WOODMOOR WELL NO. 22

TRANSMISSION LINE

SWMP, GRADING AND EROSION CONTROL PLAN

JANUARY 2024

STA: 1+00 - 11+00

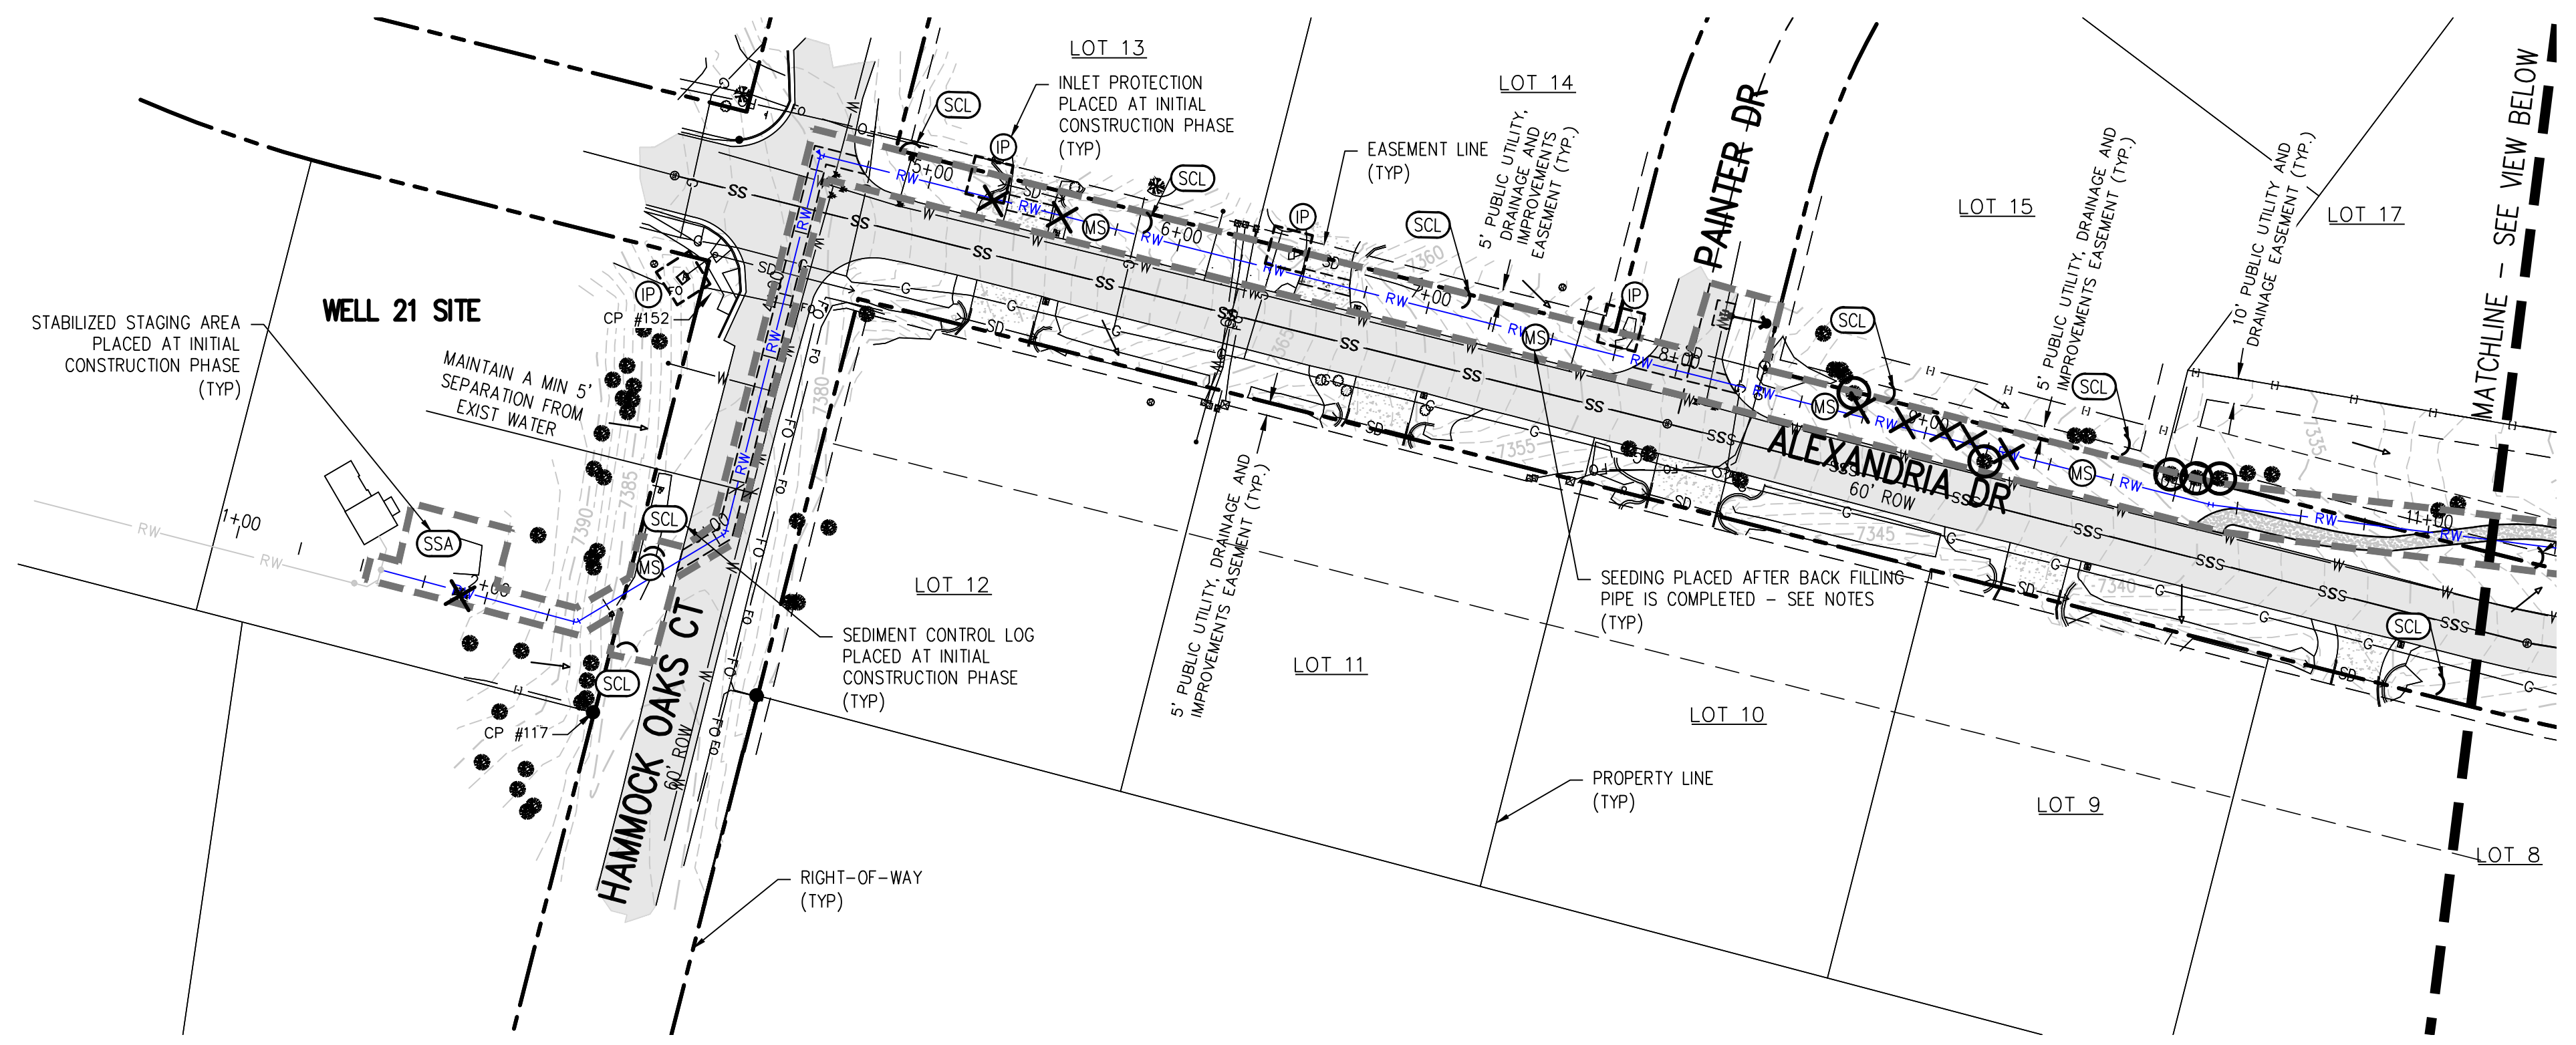
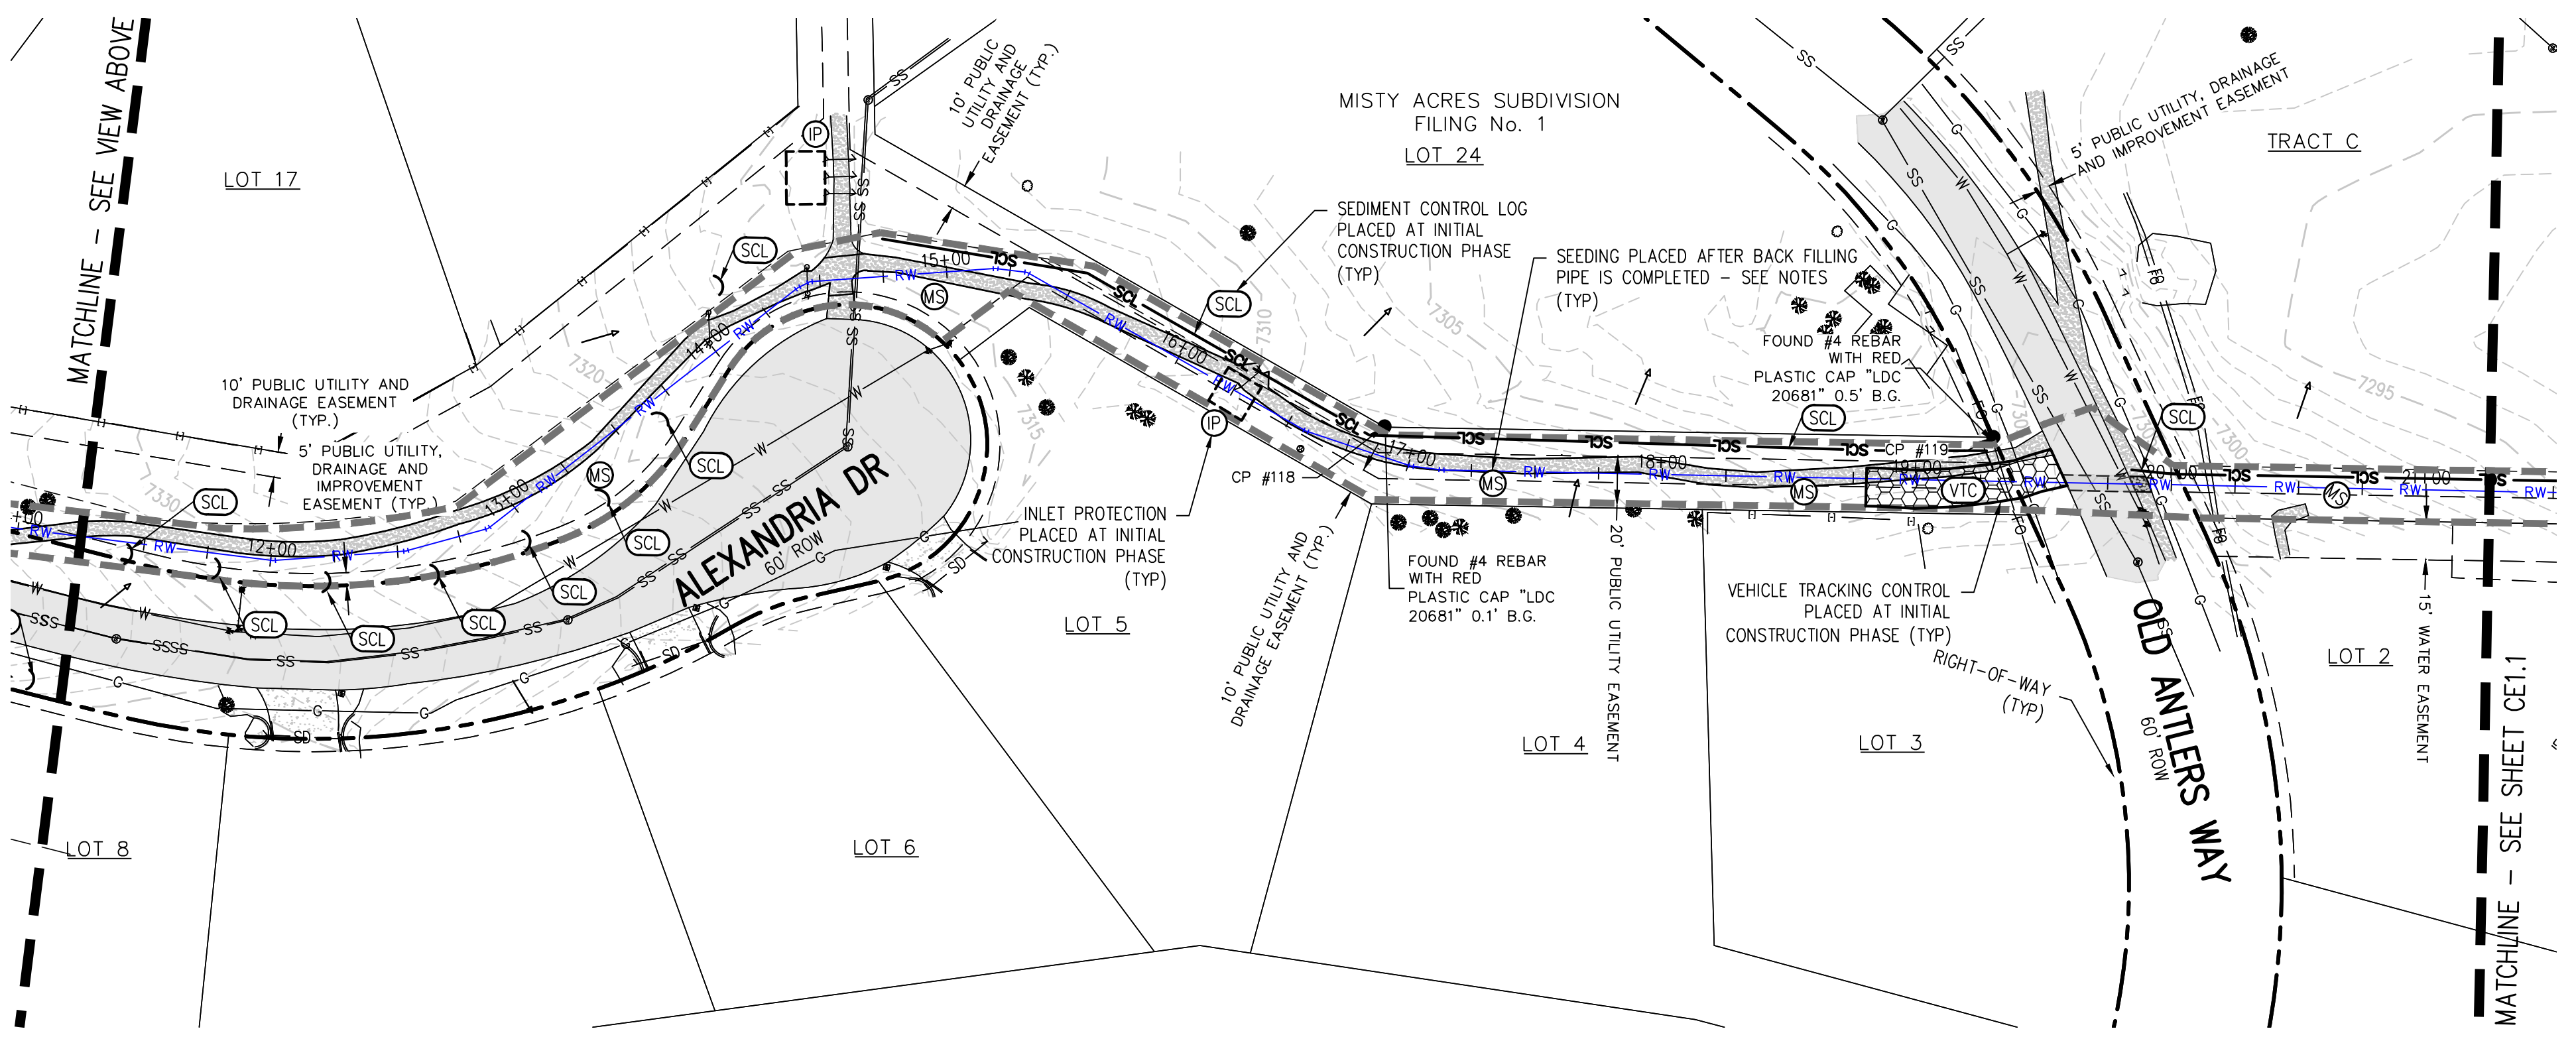
Proposed RW transmission line and Limits of Work do not align or match SWMP. Revise drawing to correct.
